**Consultation Response from KC,
Trees**

2026/92116 Clough Farm, Long Lane, Earlsheaton, Dewsbury, WF12 8LQ

Discharge of details reserved by condition 14 (Reptile Survey), 15 (CEMP-Biodiversity), 18 (Arboricultural Method Statement), 34 (bird/bat boxes) on previous permission 2024/91476 for erection of 24 dwellings

Date Responded: 04/08/2026

Tree Protection Plan			
Client			
Site/Project			
Long Lane, Earlsheaton			
Scale/Sheet		Date	
1:200 - A1		15/06/2026	
Drawing No	Rev	Drawn By	Checked By
	1	DB	SS

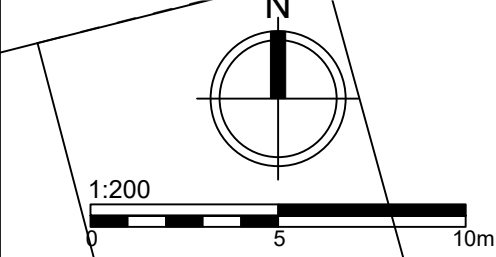
The construction of hard standing incurs the RPA of G5 and therefore the AMS and TPP should show any special engineering within RPA to reduce impacts to retained trees, as previously stated in the consultation provided by KC Trees dated 17/07/2024.

Proposed retaining walls along the south and east boundaries will require post supports being installed within the RPAs of trees. All post holes should be hand dug where within retained tree RPAs and re-sited to allow retention of tree roots >25mm diameter.

Following the depth of 500mm, where most roots are generally present, excavation can then continue with an auger attachment on plant machinery to reach the required depth of up to 5m in some areas. Tree protection fencing must be retained in position until immediately prior to construction of the retaining walls and groundworks within the RPAs of trees along the south and east boundaries.

The retaining walls are then be utilised as the tree protection scheme instead of the prior fencing, Ground Level Changes Within the RPAs Following the construction of the retaining walls, the ground levels are to be increased within the Site, with some of the areas encroaching into the RPAs of trees along the southern and eastern boundary.

Raising the ground level in the RPAs up to 150 mm is not likely to have a significant effect on the trees. However, any addition of fill to the RPAs must not be compacted and should be of coarse textured soils with a higher sand content to allow good aeration and water movement through the soil.

Should the addition of fill be greater than 150 mm within the RPAs, then the installation of an aeration system such as perforated piping must be installed within the fill to allow air and water movement through the whole depth. If plans change and any further ground level changes are required within the RPA of retained trees, these will require prior consultation with the project arboriculturist.
